Department of Primary Industries

Eagleton Quarry (SSD 7332) Comment on the Environmental Impact Statement (EIS)

Eagleton Quarry (SSD 7332) - Comment on the Environmental Impact Statement (EIS) Detailed comments – DPI Water

FIGURE 2.4
Water Catchments

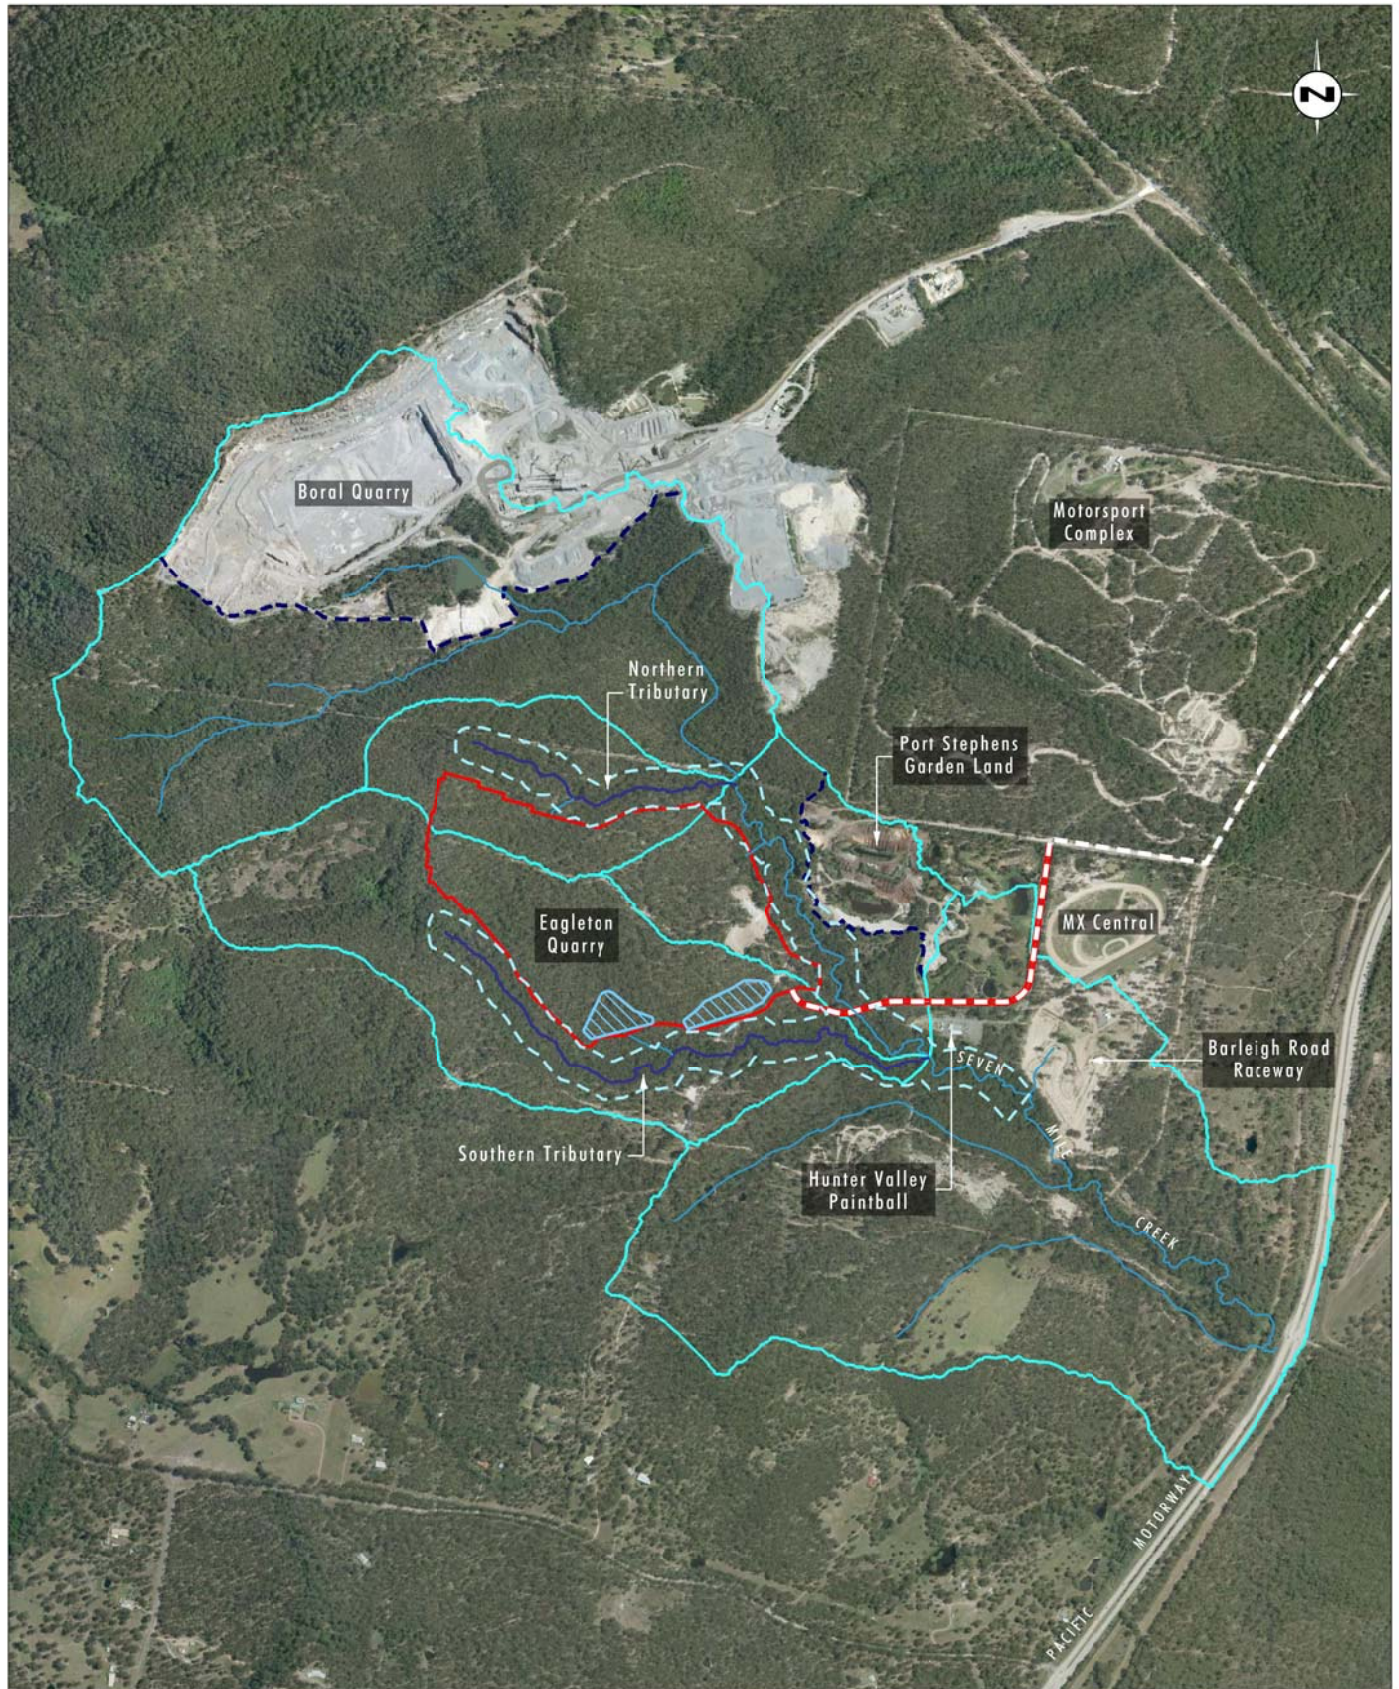
- DPI supports the inclusion of riparian corridor buffers from the watercourses on site, however it is recommended the riparian corridors be designed and implemented in accordance with the Guidelines for Controlled Activities on Waterfront Land, including riparian corridor widths as specified in Table 1 of the Guidelines for Riparian Corridors on Waterfront Land.

- Vegetated riparian corridors are to be measured from watercourse top of bank, not the watercourse centreline.
- The Biodiversity Management plan should include the following:

- o an updated plan showing the Vegetated Riparian Corridor to be maintained in relation to the watercourses and the proposed area of operation consistent with the Guidelines for Controlled Activities on Waterfront Land, including identification of the top of bank;
